(QA - 5.3) IN RESPONSE TO ITEM 5.3 OF THE QUALITY AUDIT TIMBER VEHICLE RESTRAINT BARRIER HAS BEEN PROVIDED AT SIGNIFICANT LEVEL DIFFERENCES.

Client	Keldrum Limited
Project	Large-scale Residential Development at Trillicky, Wicklow
Title	Quality Audit Response Sheet 2 of 2
Dep. No.	A034-CSC-ZZ-XX-DR-C-0052
Date	July 2023
Unit	SC
Drawn By	NB
Checked By	OS
Scale	1:500 @ A0
Revision	P2

Client	Keldrum Limited			
Project	Large-scale Residential Development at Tinikilly, Wicklow			
Title	Proposed Bridge and Culvert Arrangement			
Dwg. No.	A034-CSC-ZZ-XX-DR-C-0025			
Date	Drn. by	Chkd. by	Aprvd. by	Scale
Oct 2022	SC	NB	OS	AS SHOWN @ A1
				Revision
				P3

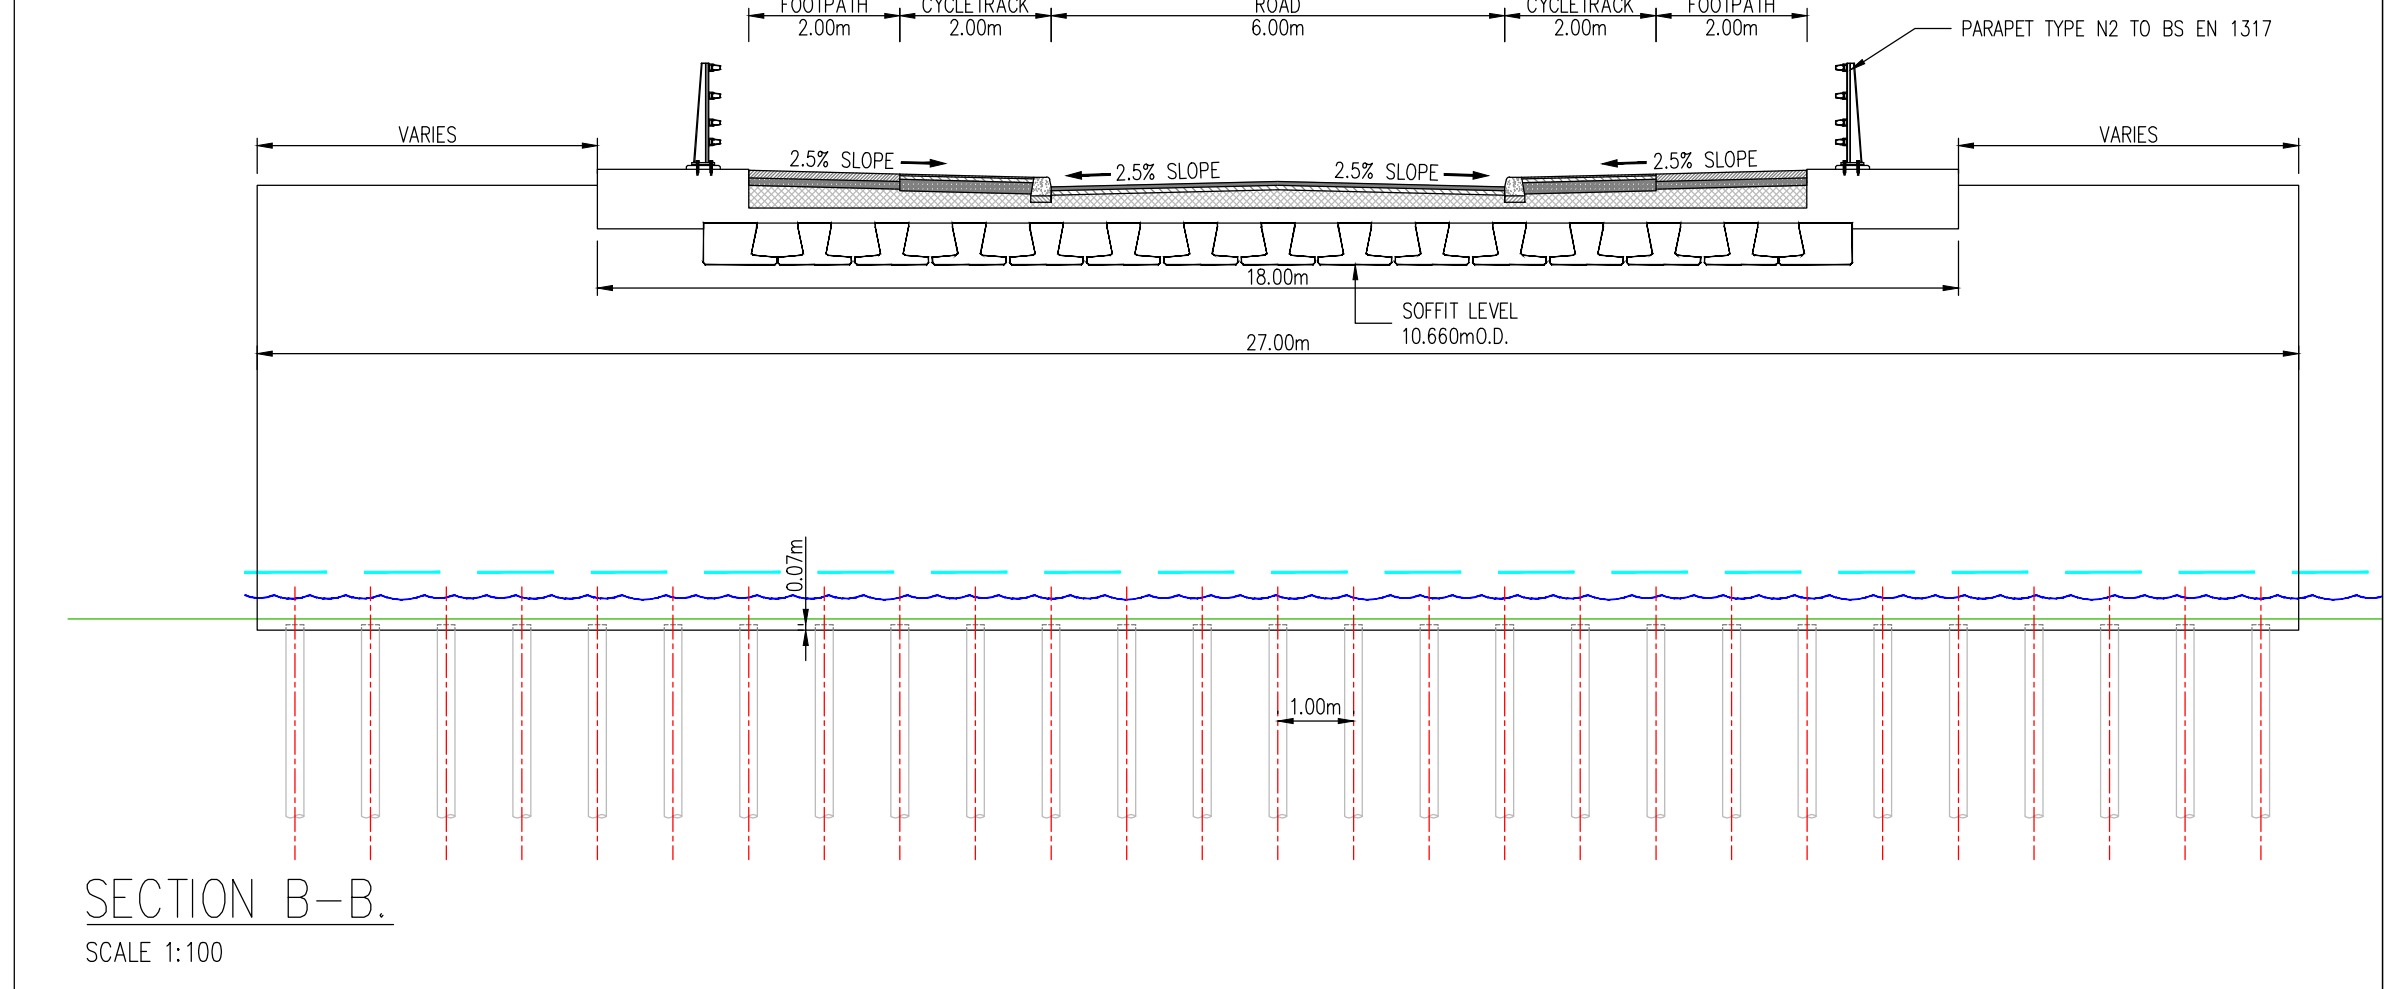
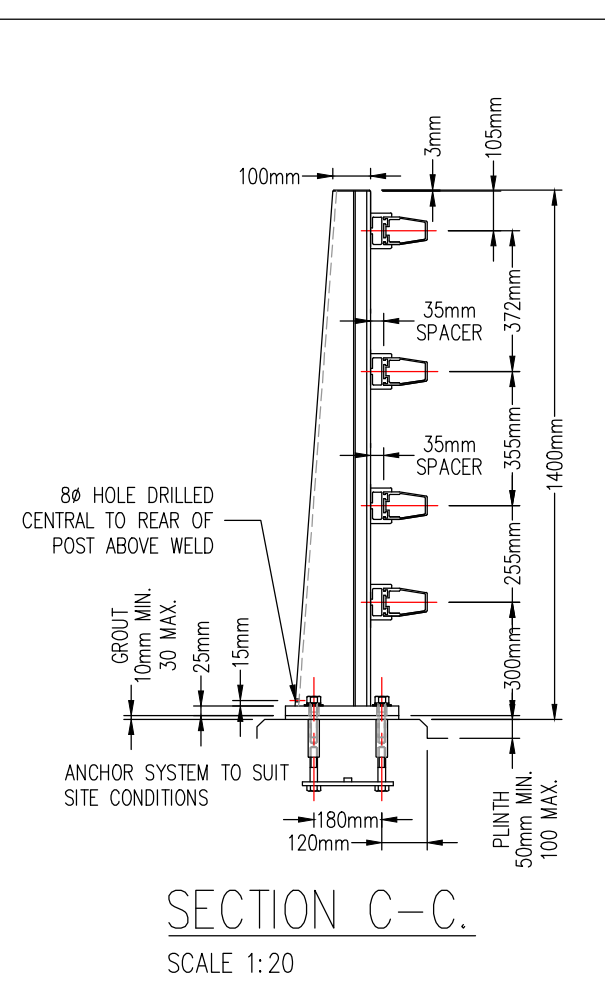
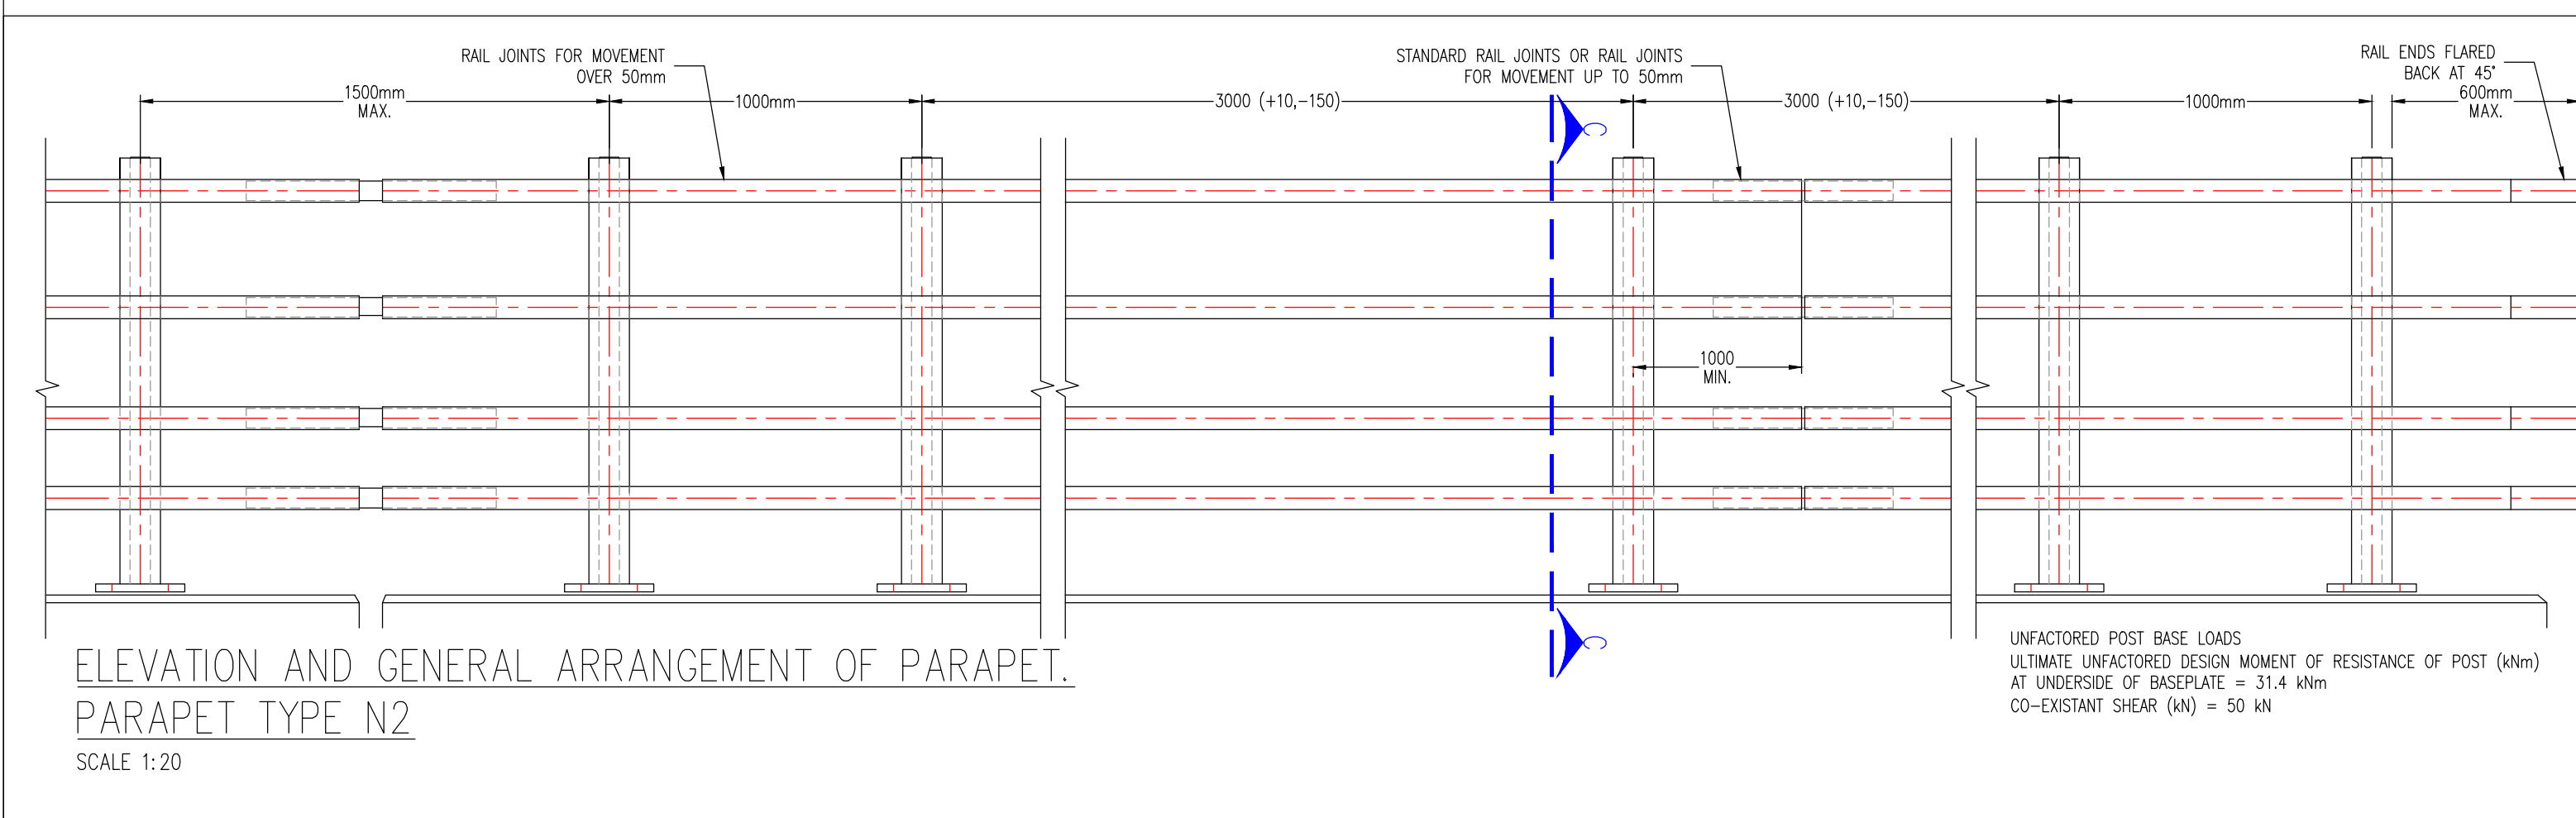
(QA - 6.4) IN RESPONSE TO ITEM 6.4 OF THE QUALITY AUDIT 1.4m HIGH NZ/M2 BRIDGE PARAPET PROVIDED TO NATIONAL CYCLE MANUAL STANDARDS REFER TO DRAWING A034-CSC-ZZ-XX-DR-C-0025.

Client	Keldrum Limited
Project	Large-scale Residential Development at Tinakilly, Wicklow
Title	Proposed Sightlines Sheet 1 of 2
Dep. No.	A034-CSC-ZZ-XX-DR-C-0039
Date	09/08/2023
Scale	1:500 @ A0
Revision	P4

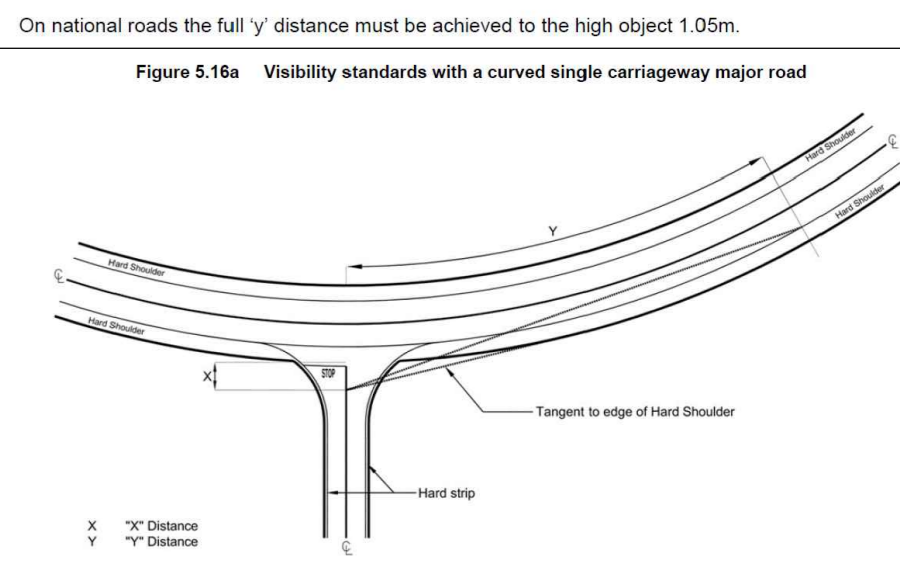
(QA - 5.6) IN RESPONSE TO ITEM 5.6 OF THE QUALITY AUDIT SIGHTLINES VERIFIED AT ALL INTERNAL JUNCTIONS REFER TO DRAWING A034-CSC-ZZ-XX-DR-C-0039-0040.

Client	Keldrum Limited
Project	Large-scale Residential Development at Tinakilly, Wicklow
Title	Swept Path Analysis Fire Tender
Doc. No.	A034-CSC-ZZ-XX-DR-C-0023
Date	15.08.2023
Drawn by	SC
Checked by	NB
Scale	1:500 @ A0
Revision	P6

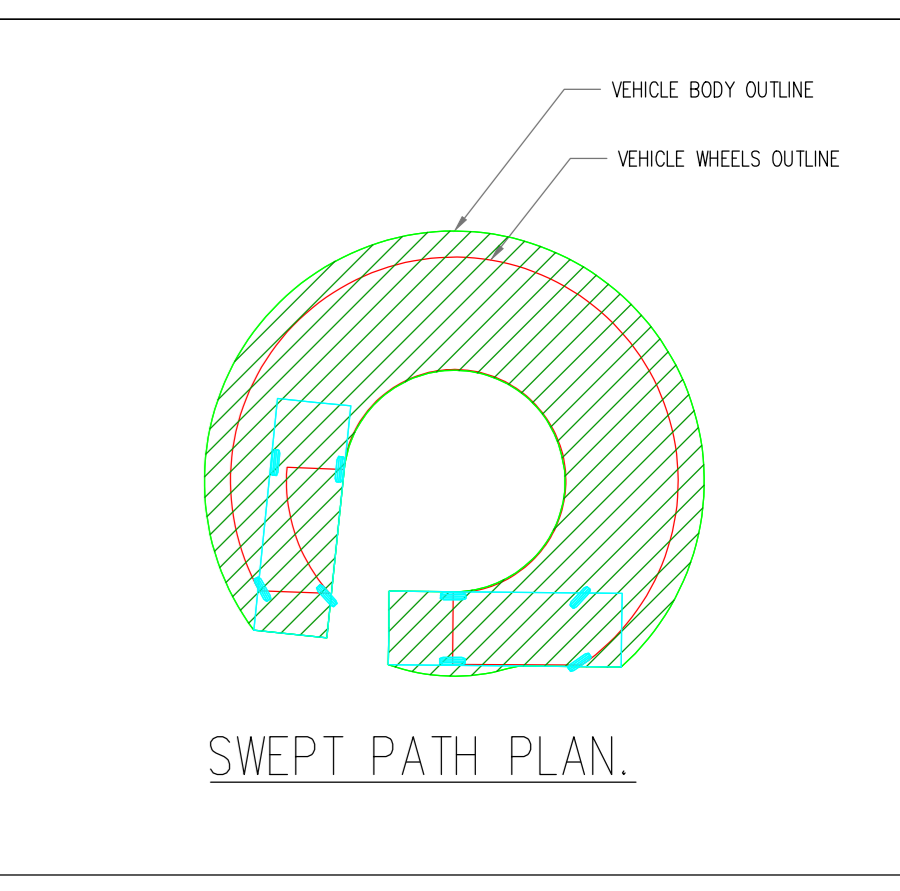
(QA - 6.2) IN RESPONSE TO ITEM 6.2 OF THE QUALITY AUDIT IT HAS BEEN ENSURED THAT FIRE TENDER VEHICLE SWEEP PATHS NEED NOT OVERHANG FOOTPATHS. REFER TO DRAWING A034-CSC-ZZ-XX-DR-C-0023.
